CITY OF PORTLAND, MAINE

Project Name: 197 Spring Street Renovation and Alteration
Address: 197 Spring Street
Applicant: WAIT, LLC
Planner: Matthew Grooms, Planner

On May 9, 2017, the Planning Board considered [197 Spring Street Renovation and Alteration] for a building addition, parking lot improvements, and converting the building into 7 residential units. The Planning Board reviewed the proposal for conformance with the standards of the Subdivision Ordinance and Site Plan Ordinance. The Planning Board voted unanimously to approve the application with the following waivers and condition(s) as presented below.

RE: Staff Review Comments for 197 Spring Street (2017-061) – Planning Board Review

Drawing file: 1. Original Plans / Plan 14. Elevations - 1.pdf

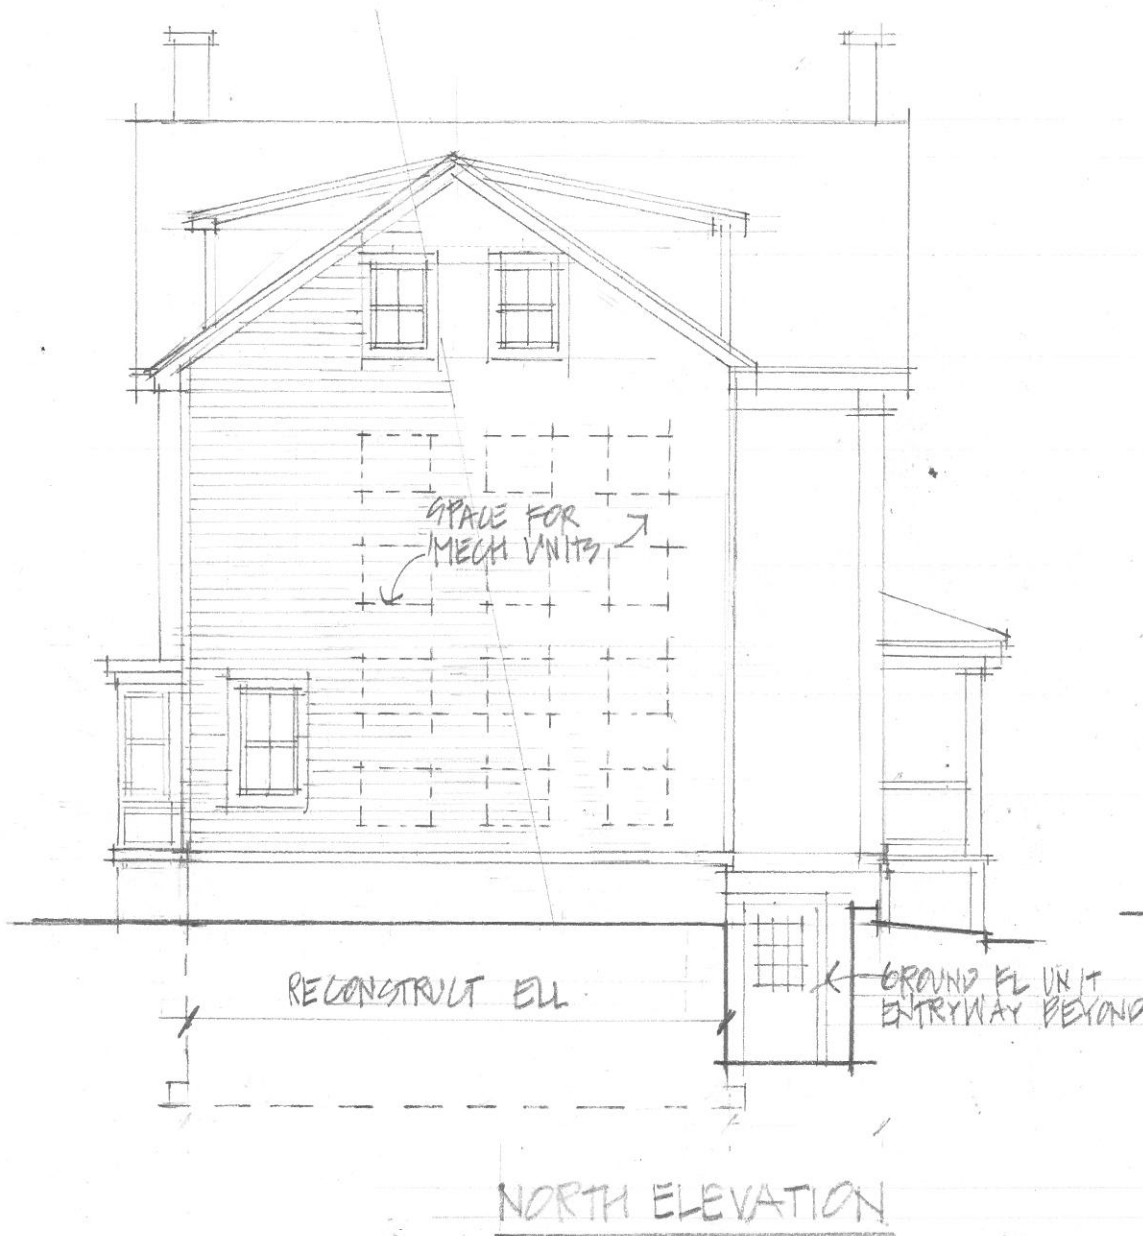
3. The applicant shall provide a photometric plan and associated detail sheets which demonstrate acceptable light trespass;
4. The applicant shall provide revised elevation sheets with spot grades and building dimensions that illustrate building height;

DRIVEWAY APRON LAYOUT DETAIL
NOT TO SCALE

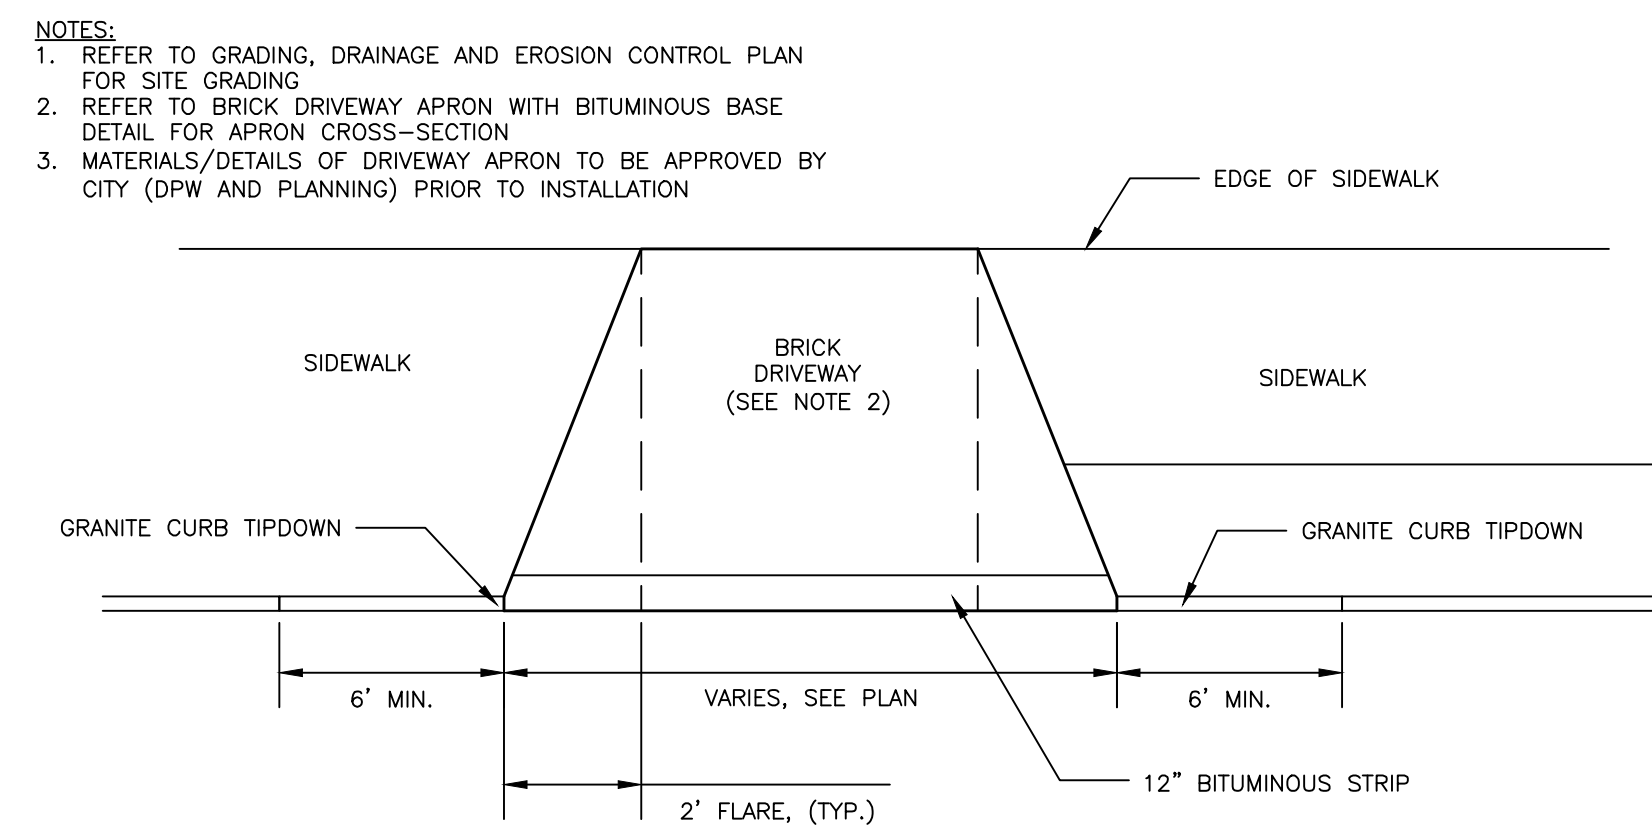
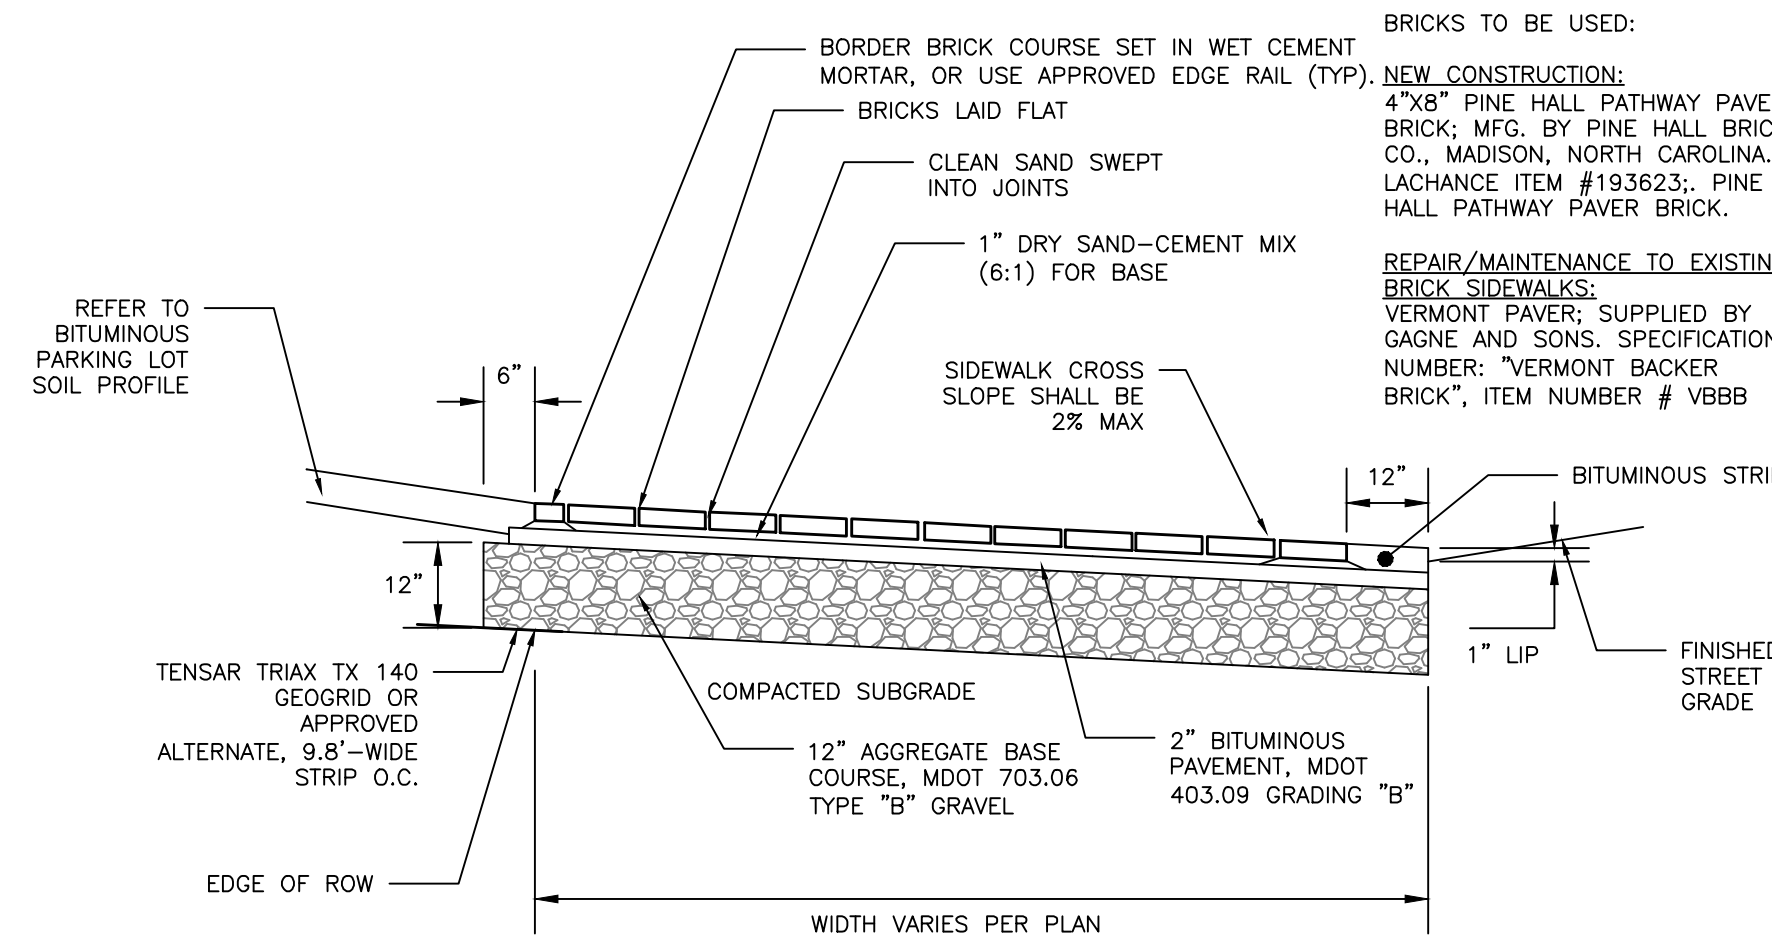
2. The applicant shall submit a final driveway apron detail meeting *Technical Manual* standards for review and approval by the Department of Public Works; and
